Recommendation Report for Planning Permission for Works or Extension to a Dwelling

REF NO: AL/50/20/HH

LOCATION: Limmer Pond Cottage
Nyton Road
Aldingbourne
PO20 3TX

PROPOSAL: Replacement of existing conservatory with new garden room.

CONSERVATORY
REPLACEMENT:
PROPOSED
ELEVATIONS

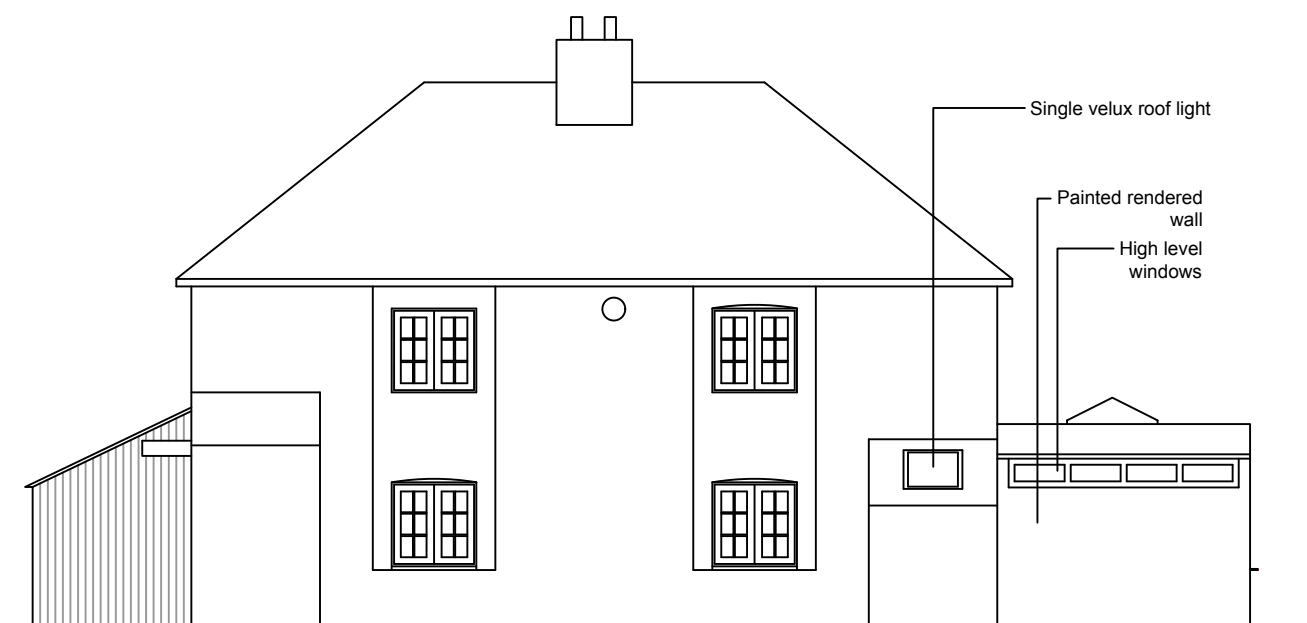
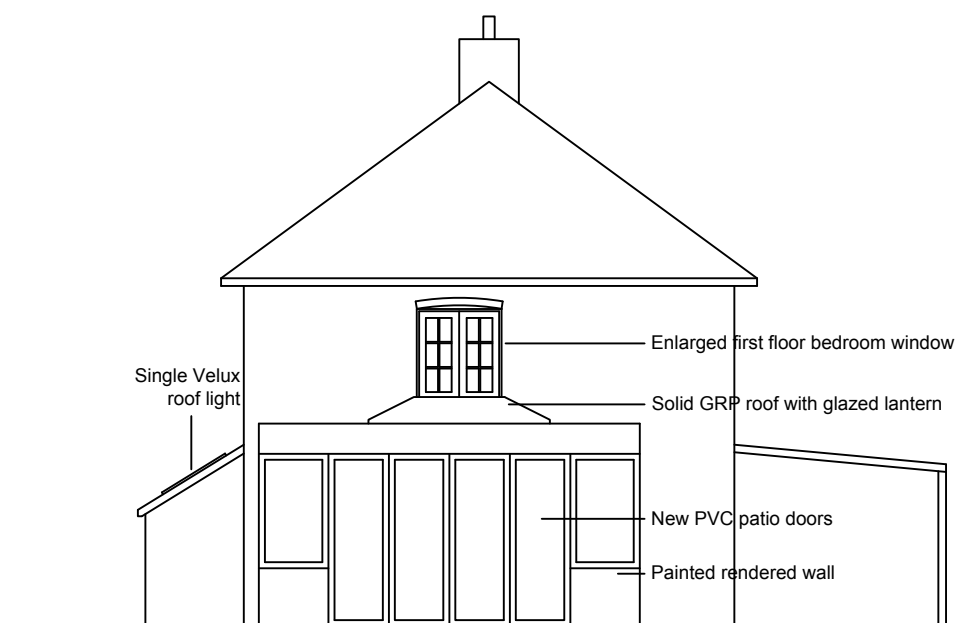
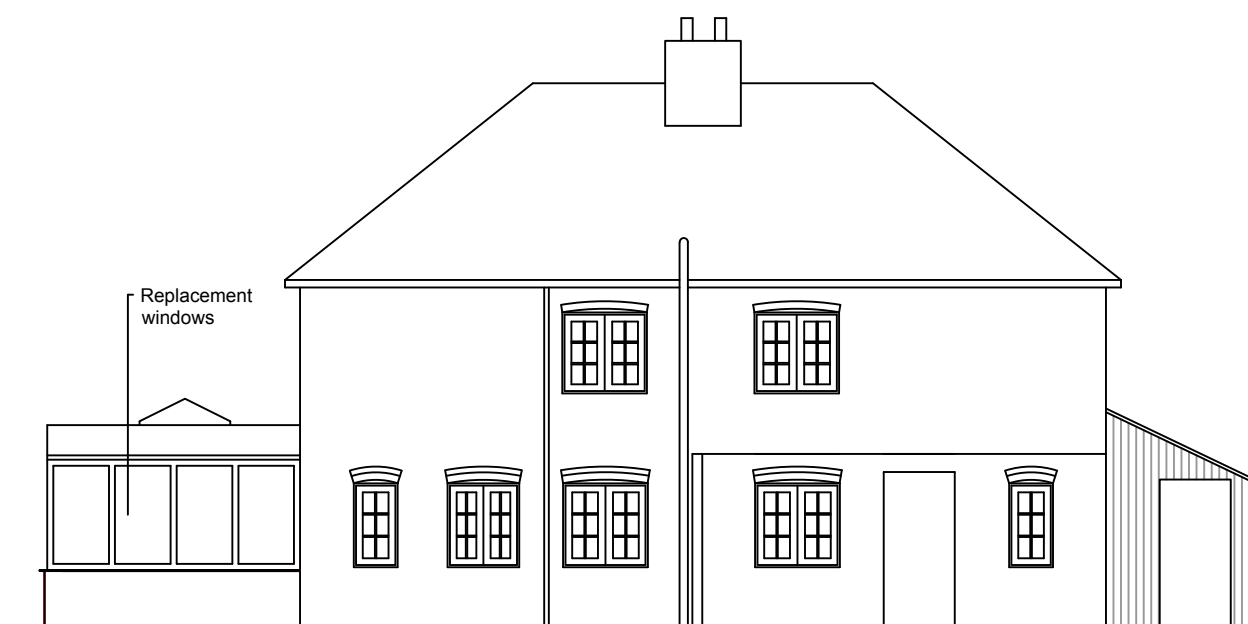
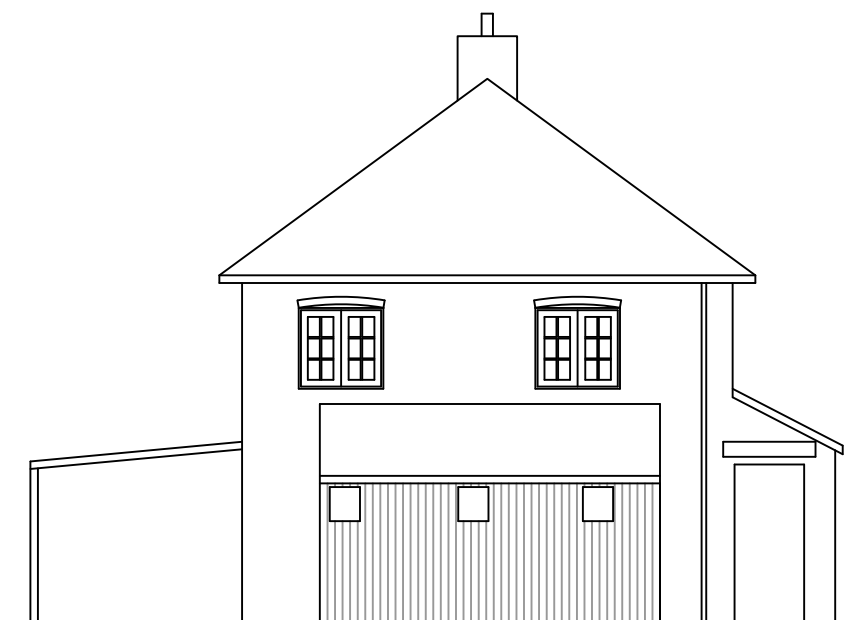
The conservatory remains similar in appearance to that which already exists although will increase in depth by 0.35m. The windows which front the road to the south west will be reduced in size.

To the rear elevation, the first floor window will also increase slightly in size, however this is not visible from the street scene.

The conservatory will increase in depth slightly by around 0.35m and have a maximum height of 3.1 with rooflight.

CONSERVATORY
REPLACEMENT:
FIRST FLOOR PLANS

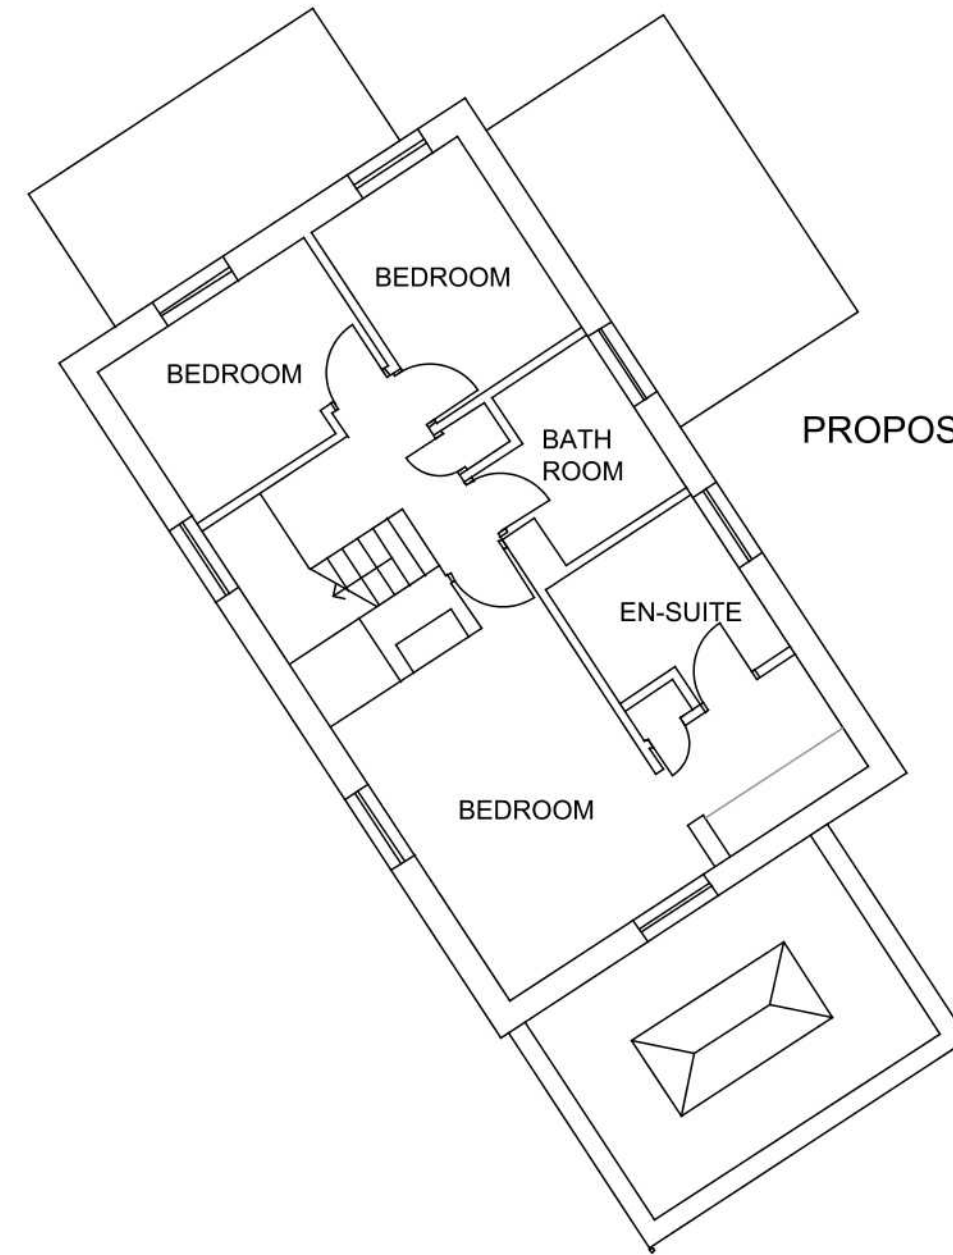
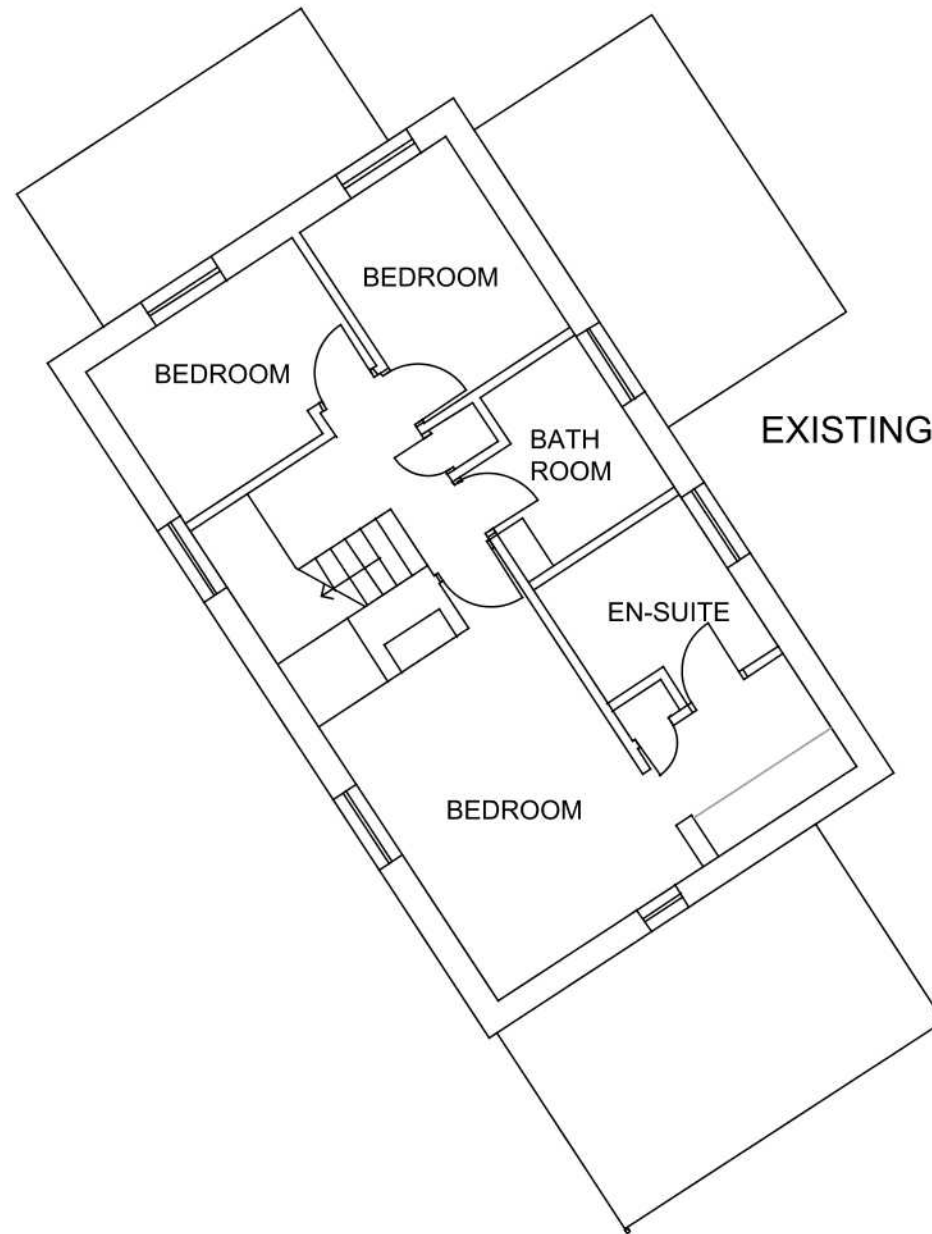
The first floor window to the southern elevation will increase slightly in size however is not considered to provide additional views with 24m retained to the boundary
